Our Ref: R/293/17/HH
Your Ref:

Town & Country Planning Act 1990 (as amended)
Town & country Planning (Development Management Procedure) (England) Order 2015
Application for Planning Permission for Works or Extension to a Dwelling

Development Two storey rear extension, revised fenestration & solar panel to south elevation.
Location 92 Sea Avenue Rustington

Block Plan 1:500
Ordnance Survey (c) Crown Copyright 2017. All rights reserved. Licence number 100022432

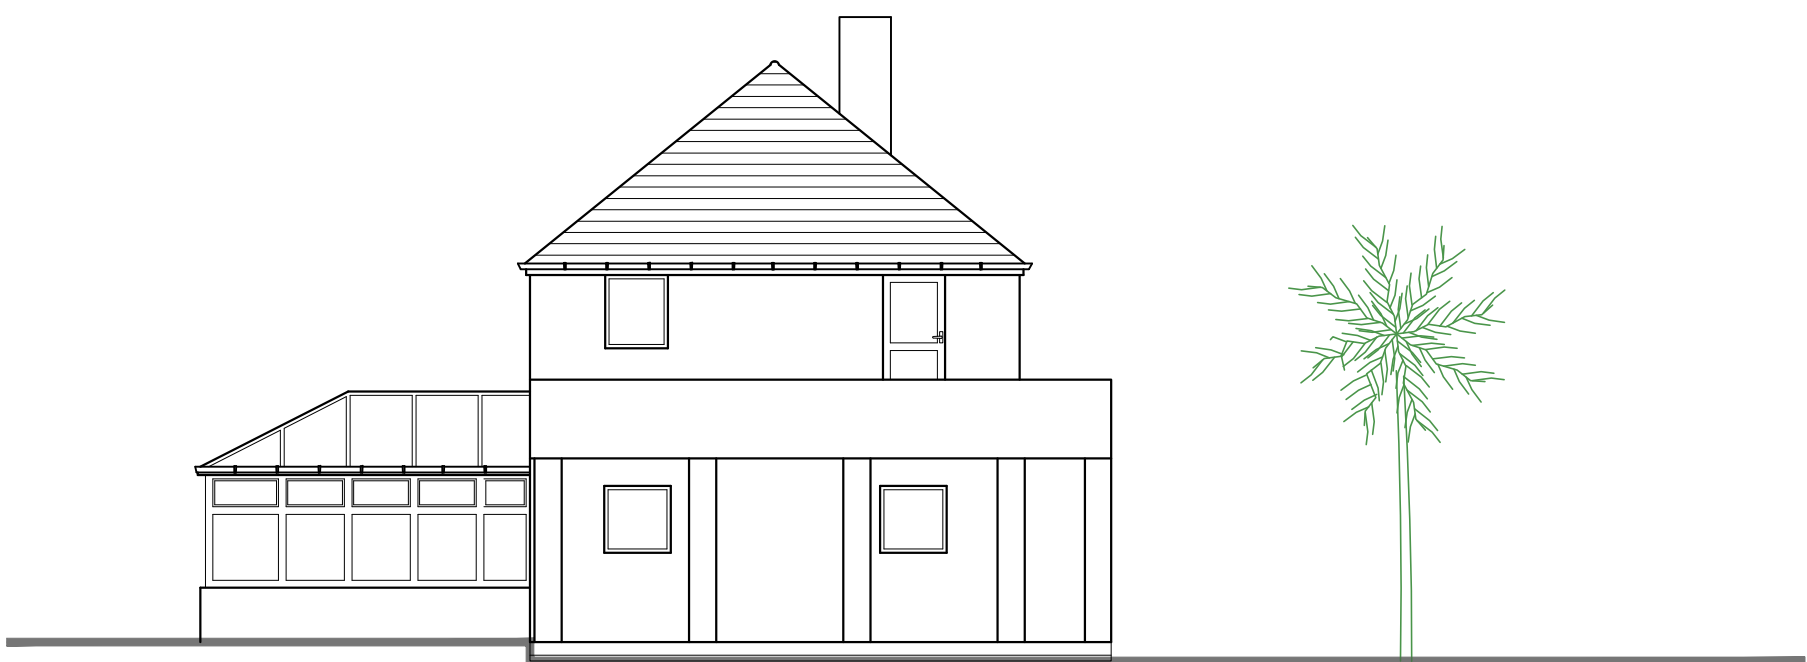
Please submit 1 electronic or 3 paper copies of a block/site plan at a scale of 1:500 or 1:200. Further details of what must be included on the plan can be found in the National Validation Requirements. Please clearly highlight the proposed works and provide measurements from the proposal to the site boundaries.

First Floor  
1:100

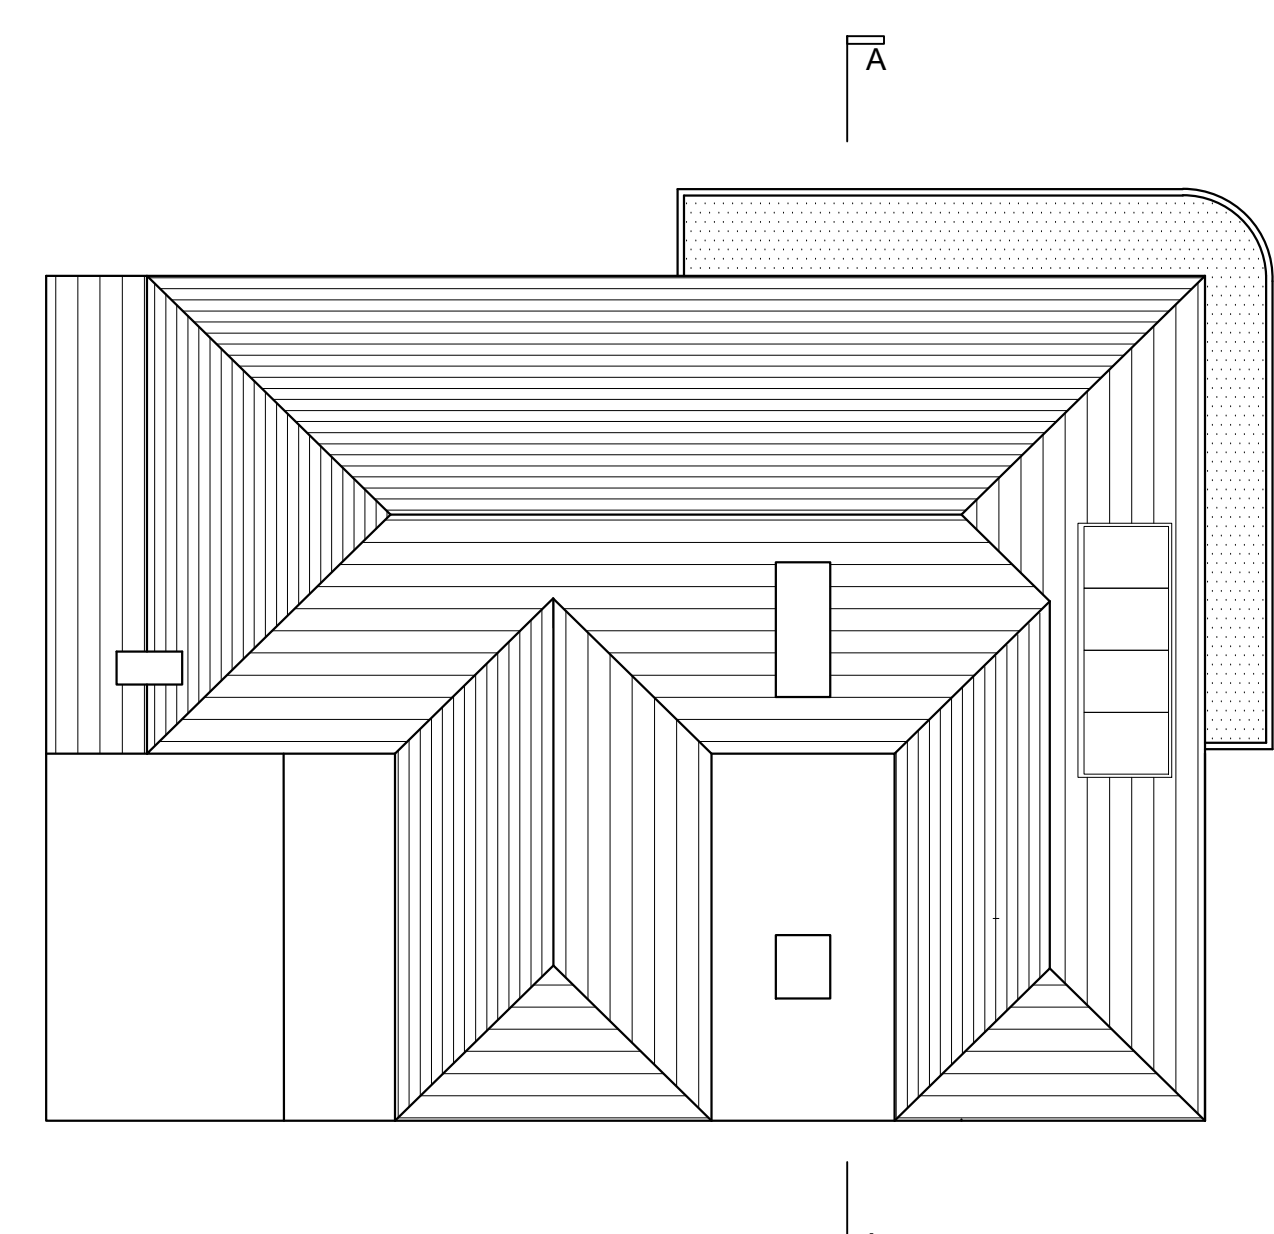
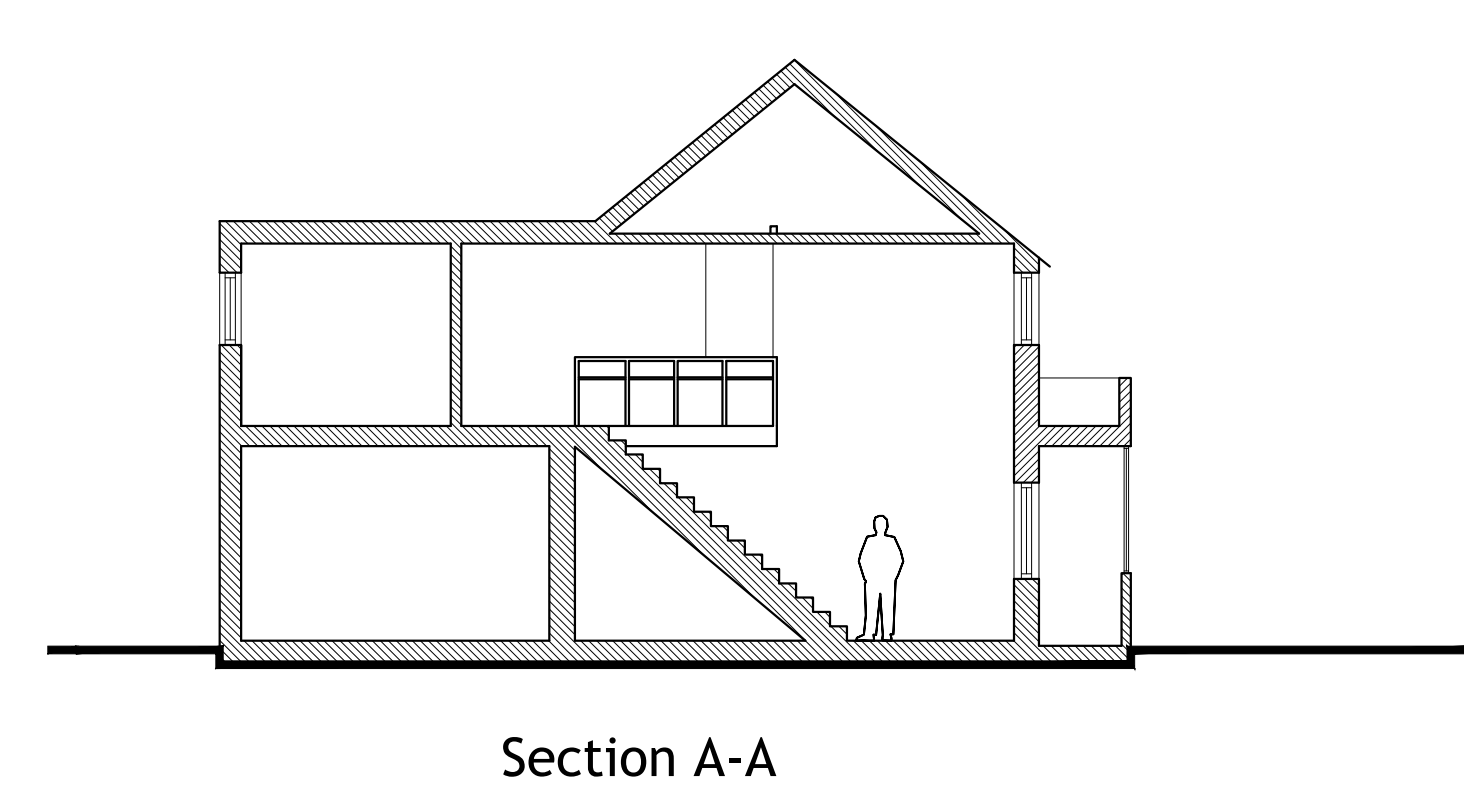
The proposed first floor plan and north elevation do not accord. Please amend accordingly.
